**Consultation Response from KC,
Highways Development Management****2023/92023 Propermaid Ltd, 4, Marsh Gardens, Honley, Holmfirth, HD9 6AP****Change of use from general industry B2 to storage and distribution B8****Date Responded: 7-3-2024.****Responding Officer: Mark Berry.****Responding Ref: 3-40-20.**

This application seeks approval to the change of use from general industry B2 to storage and distribution B8 at Z A Enterprises Ltd, 4, Marsh Gardens, Honley, Holmfirth.

Description
SITE PLAN

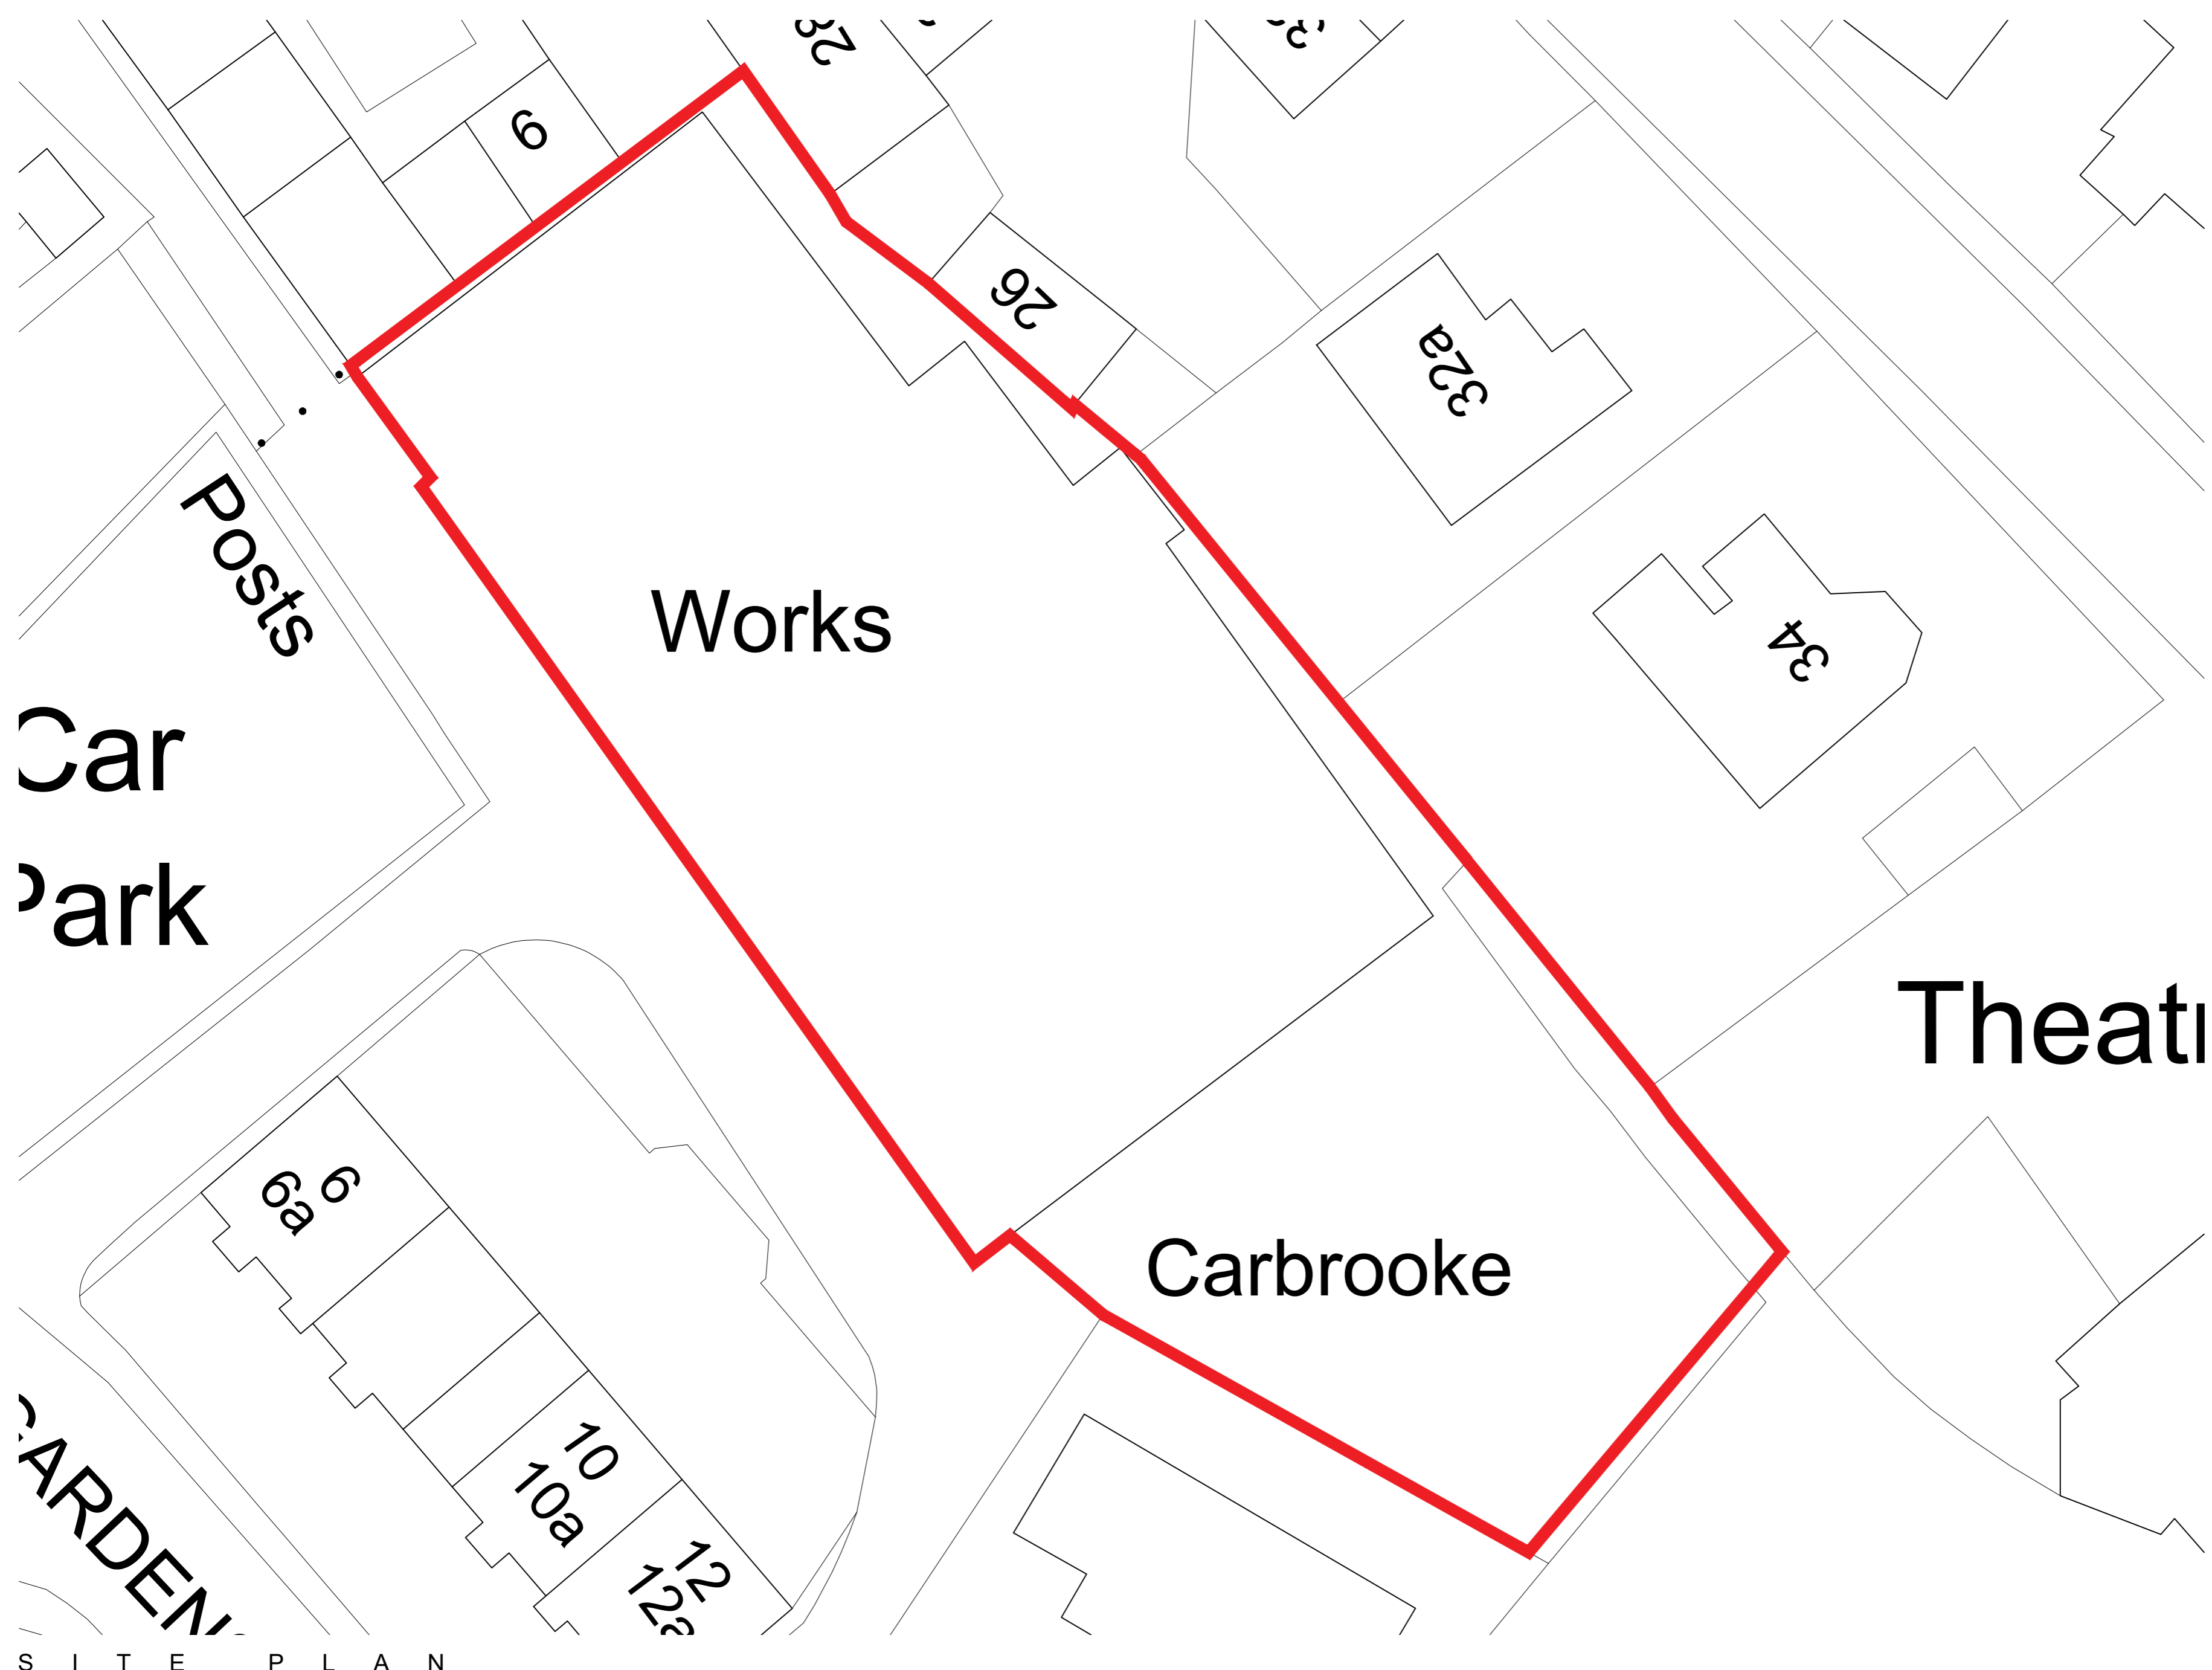
Given the relatively low traffic generation quoted by the applicants Highways Development Management have no objection to these proposals in principle. The applicants should however be asked to clarify the parking, HGV parking and HGV servicing arrangements.

This application provides insufficient information to allow a proper highway assessment to be undertaken. Further information is required as follows:

1, Vehicle swept paths should be provided to demonstrate that the largest vehicle anticipated to visit the site (16.5 m articulated lorry) can enter and exit and turn within the site.

2, A plan showing the layout of the proposed parking areas should be provided. Note these should not obstruct HGV turning movements.
